OUT15/34461

**Rix's Creek Mine Extension Project (SSD_6300)
Response to exhibition of Environmental Impact Statement**

Rix's Creek Extension project (SSD 13_6300) Response to exhibition of Environmental Impact Statement DPI Water – Detailed Comments

CALIBRATION MODEL – MODELLLED GROUNDWATER LEVELS VERSUS OBSERVED FIGURE 8.13

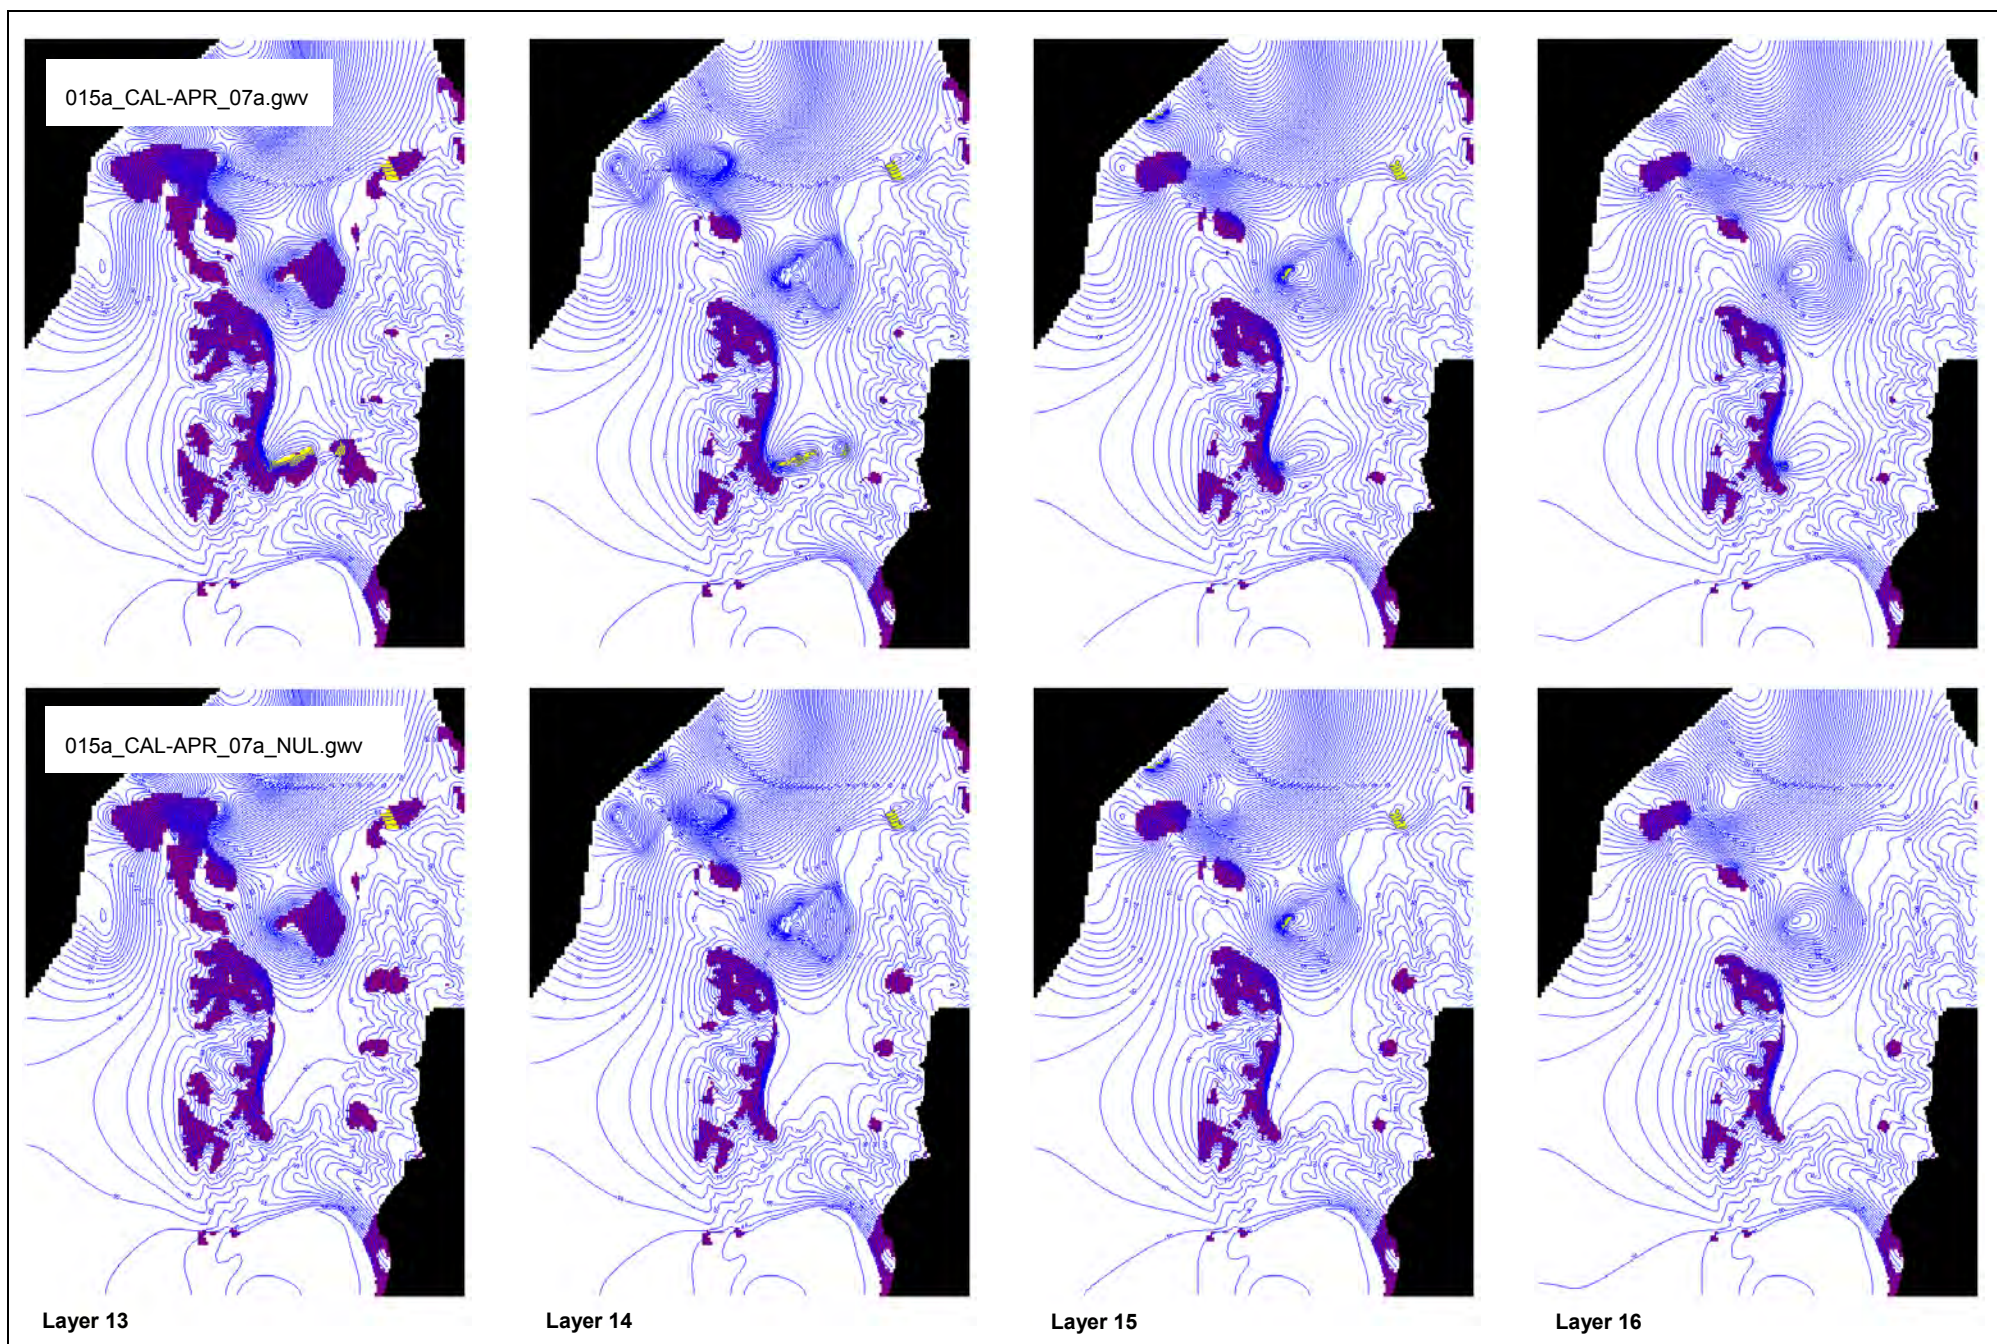
2. The model was not calibrated. A scaled root mean squared error (SRMS) of 16% was achieved. The Australian Groundwater Modelling Guideline recommends ~10%. The calibration hydrographs were not legible so no analysis of the calibration was performed by DPI Water.

8. The calibration dataset type should be better described and it is unclear where the calibration points are situated as no legible map has been provided.
